CITY OF PORTLAND, MAINE

Project Name: Jewish Community Center and Preschool/Daycare
Conditional Use and Level III Site Plan

Project #: #2015-058 (Conditional Use and Site Plan)

On July 14th, 2015, the Planning Board considered the Conditional Use and Site Plan application for the construction of a neighborhood center (defined as a "Place of Assembly") and preschool/daycare on the site of the existing St. Patrick's Catholic Church at 1342 Congress Street. The project includes demolition of the existing church (14,960 sq. ft.) and construction of a single story 19,300 sq ft building on a site of 91,126 sq feet. The Planning Board reviewed the proposal for conformance with the standards of the Conditional Use Review and Site Plan Ordinance, and approved the application with the following waivers and conditions as presented below.

SITE PLAN

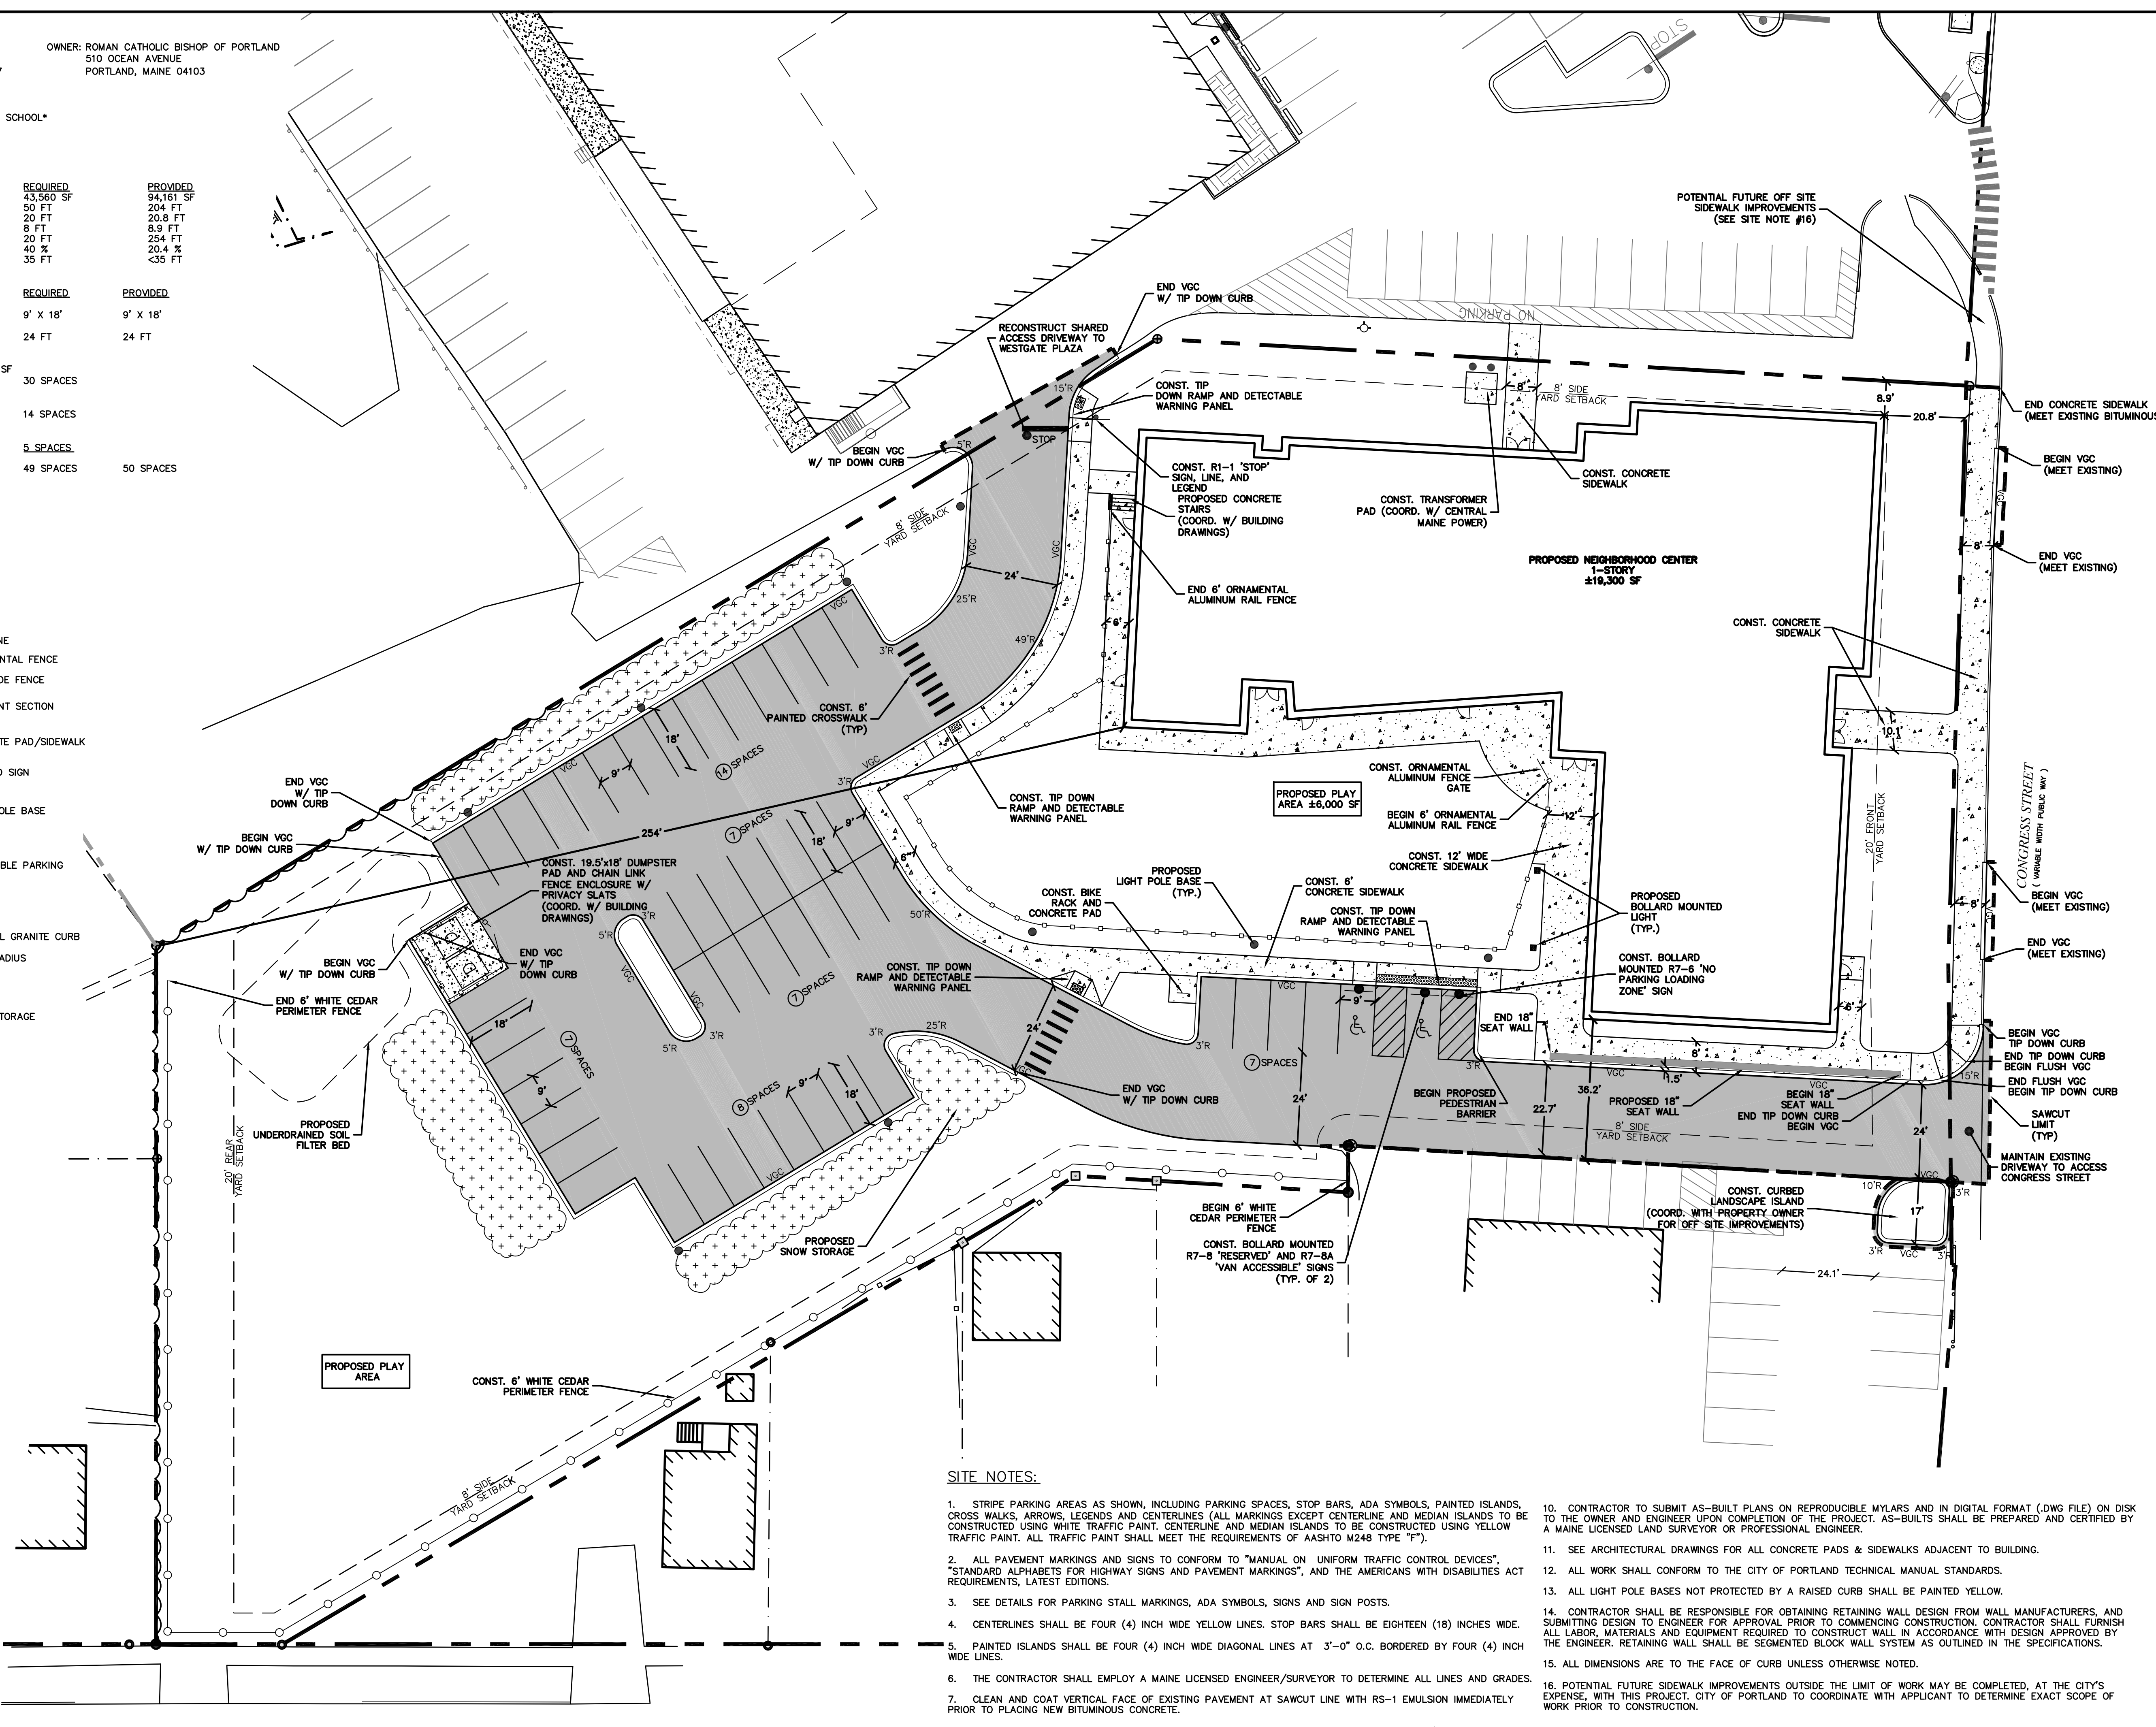
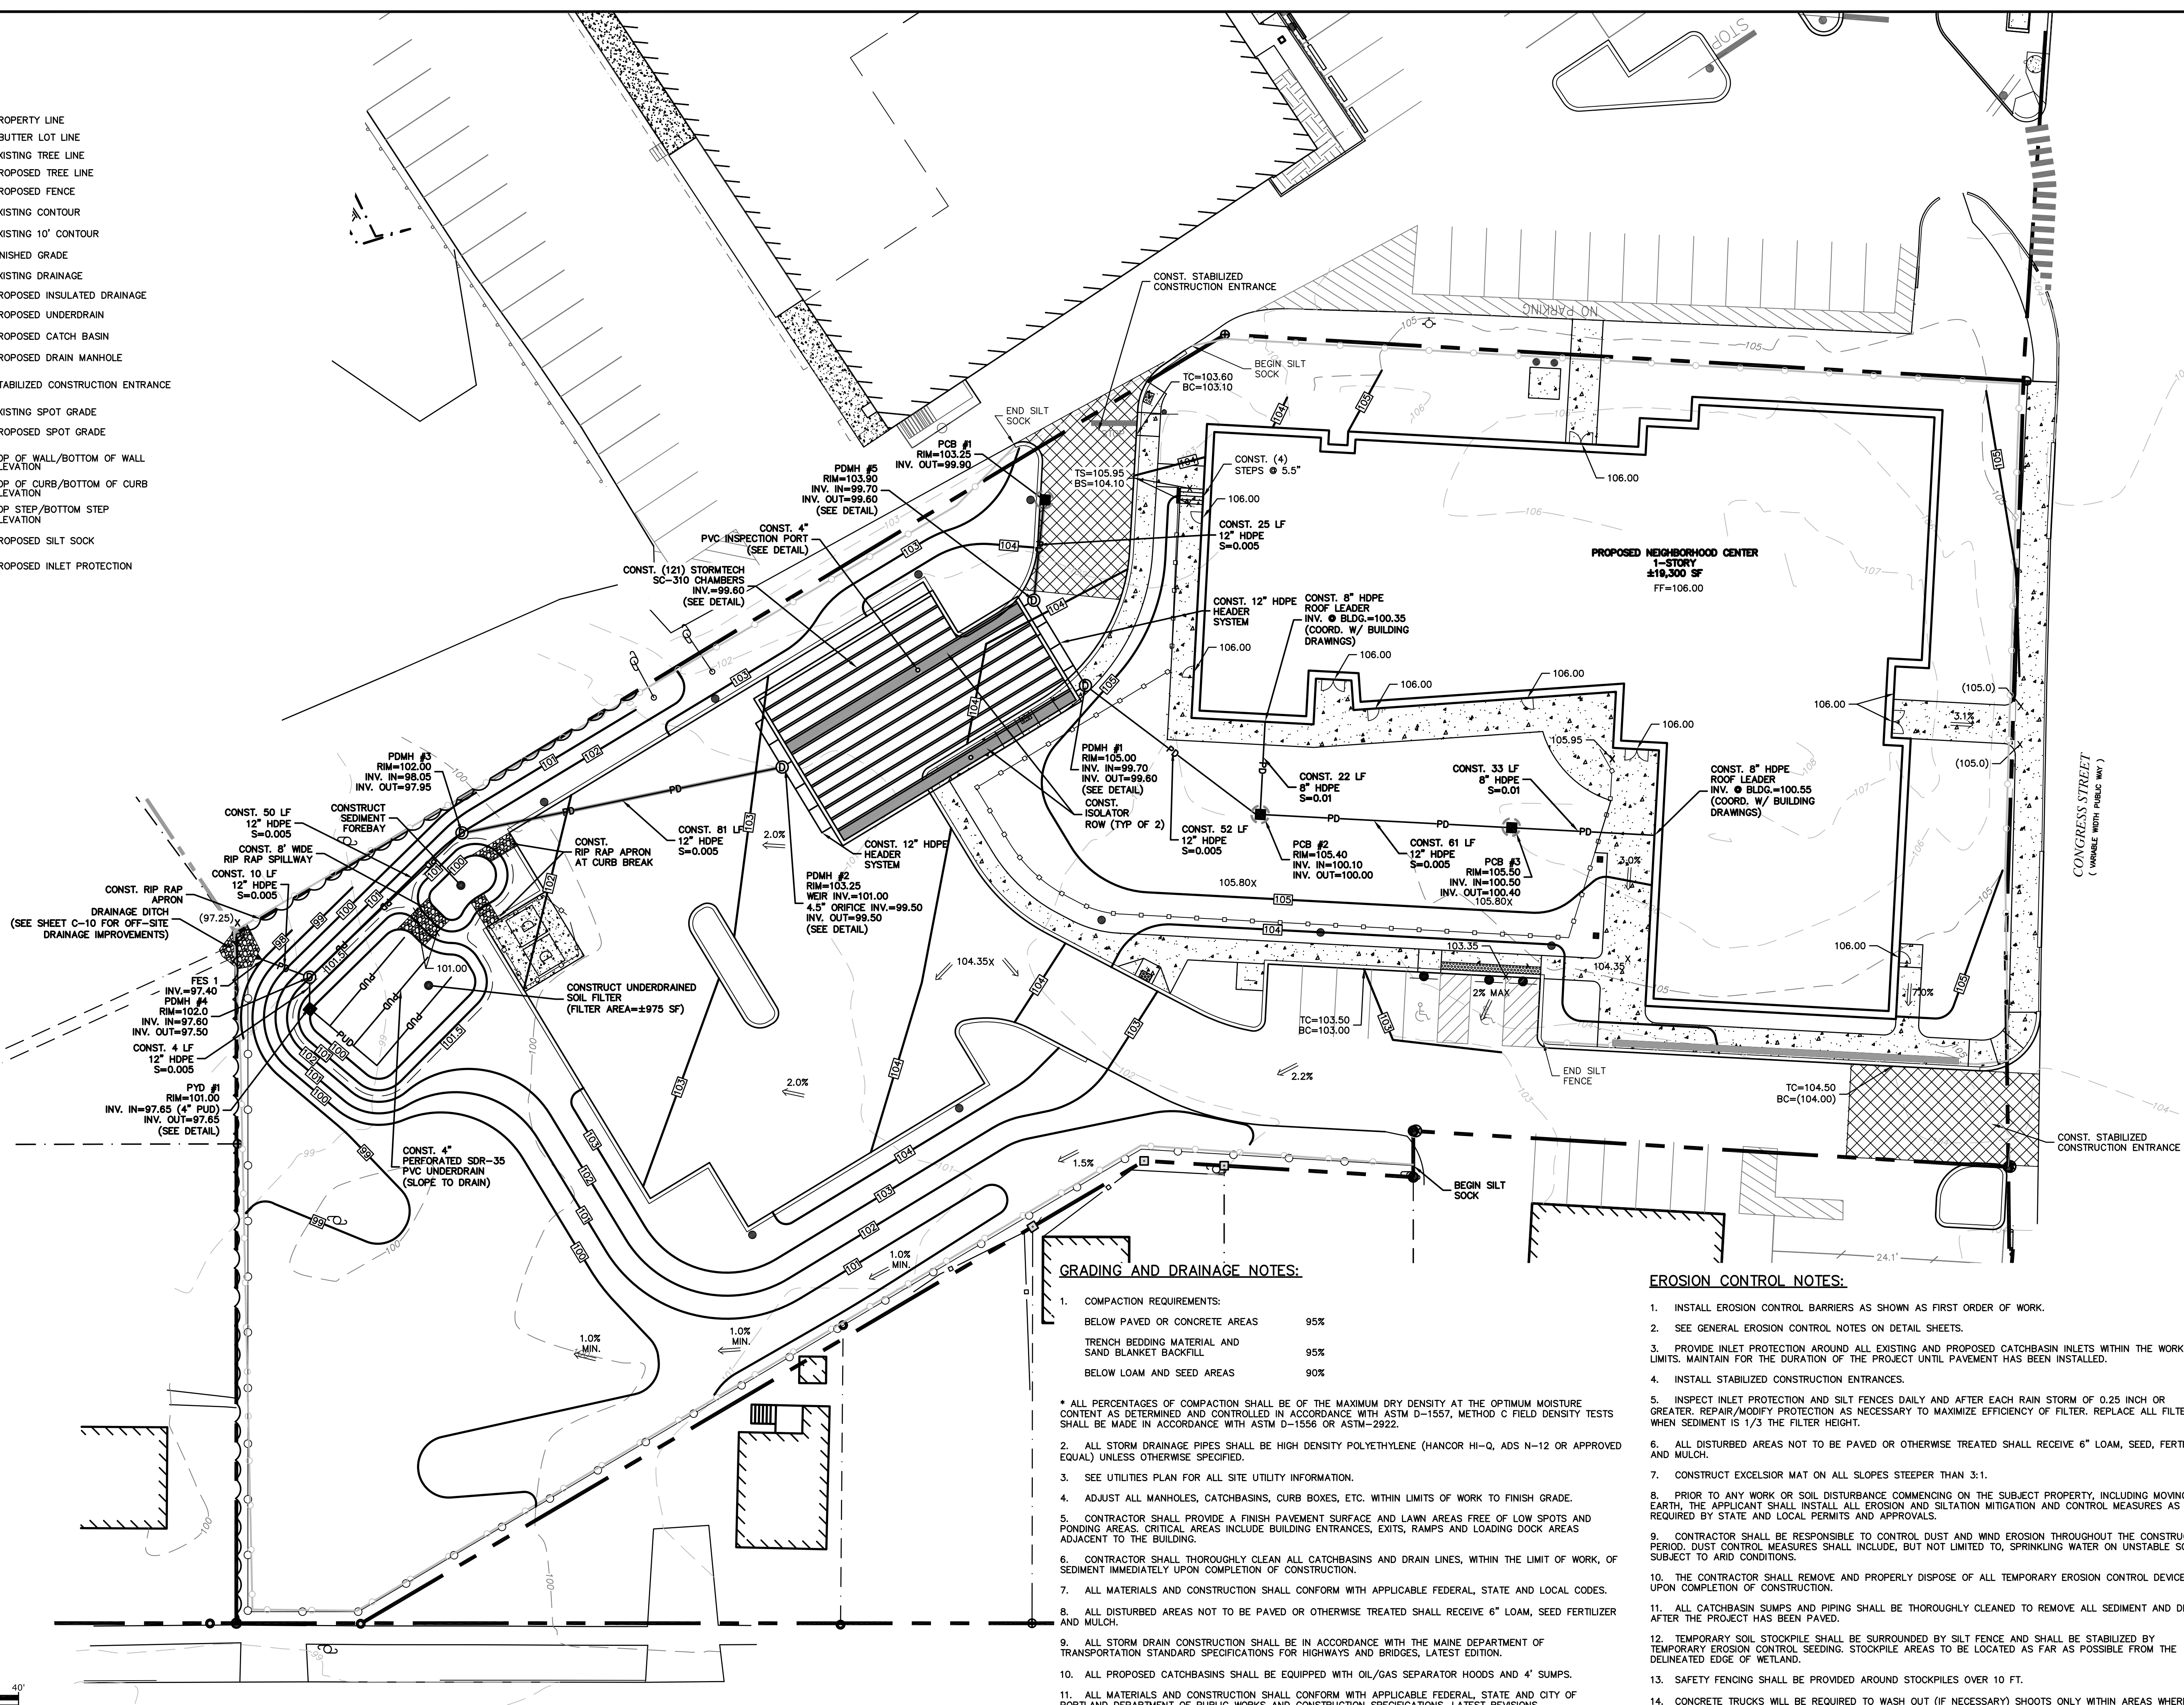
- iii. That the applicant revise the curb ramp layout at Congress Street in accordance with the comments of Tom Errico dated June 26, 2015, with revised plans to be reviewed and approved by the Planning

- The driveway entering the site from Congress Street is noted as having a width of 22.7 feet. This width (in the area where parking maneuvers occur) does not meet City standards and thus a formal waiver should be requested by the applicant.

Status: The curb ramp layout should be revised so that the ramp flare does not impact accessibility along the sidewalk route. Having a tip-down design will help to address this issue.

Status: I have reviewed existing JCA activity at their current Portland site and I have recommended that a barrier be constructed that prevents pedestrians from accessing the building entrance near Congress Street. The applicant has revised the site plan to include a 18" sitting wall along the curb. While the height of the wall is mountable by pedestrians, I do believe the physical presence of the wall will deter drop-off and pick-up activity near Congress Street. Accordingly, I find conditions to be acceptable.

Status: I find the proposed driveway width to be acceptable given that most vehicles will be passenger cars and that a secondary driveway via the Westgate Shopping Center will be provided. I support this waiver request.
